From: Mark Warwick <Mark.Warwick@arun.gov.uk>
Sent: 11 November 2019 14:30
To: Andrew Wood <Andrew.Wood@arun.gov.uk>
Cc: Planning.Responses <Planning.Responses@arun.gov.uk>
Subject: RE: 19309 Crete Nurseries, Dappers Lane - A/104/19/RES - tree comments

i) 2.0 BOUNDARY & GARDEN FENCING WITHIN RPA OF HORNBEAMS TO NORTH OF SITE

ii) 3.0 RESURFACING OF THE ACCESS ROAD WITHIN THE RPA OF T07

Plate 2: Garden & Boundary Fences

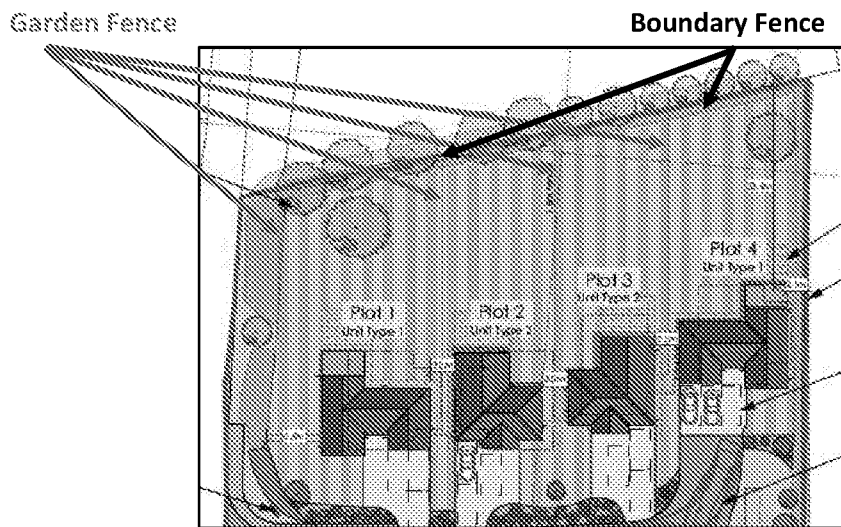
Para 2.7

- Concrete has been proposed for use within the excavations to stabilise the fence posts, yet there is no mention of how the soil/roots would be protected from that material. Leachate from curing concrete can be toxic to tree roots, therefore all pits must be lined with impervious membrane before pouring concrete.

Plate 4: RPA of T07 in Relation to the Existing Hardstanding Access Track
Dominant Category A Oak Tree (T07) With 9.15m RPA Superimposed

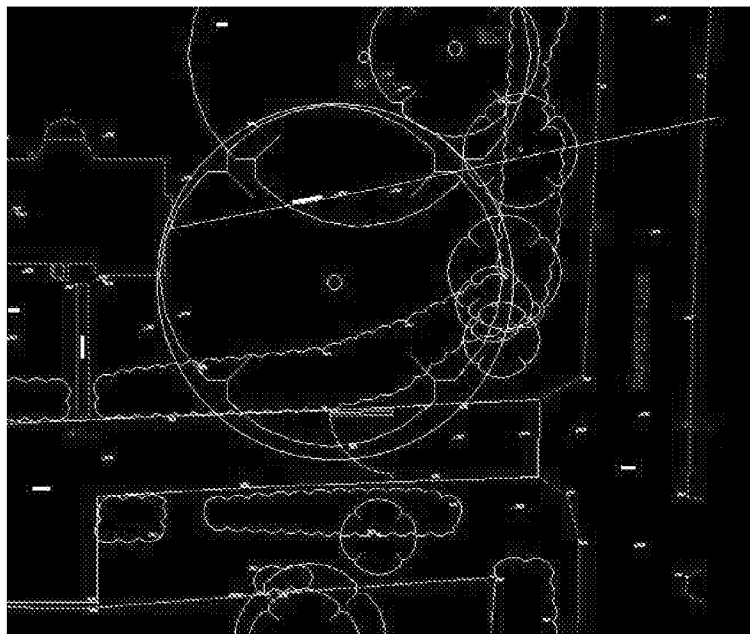
- Acceptable proposals that will be subject to a schedule of auditable supervision by the project arboriculturist to be agreed with the LPA at a pre-commencement site meeting.
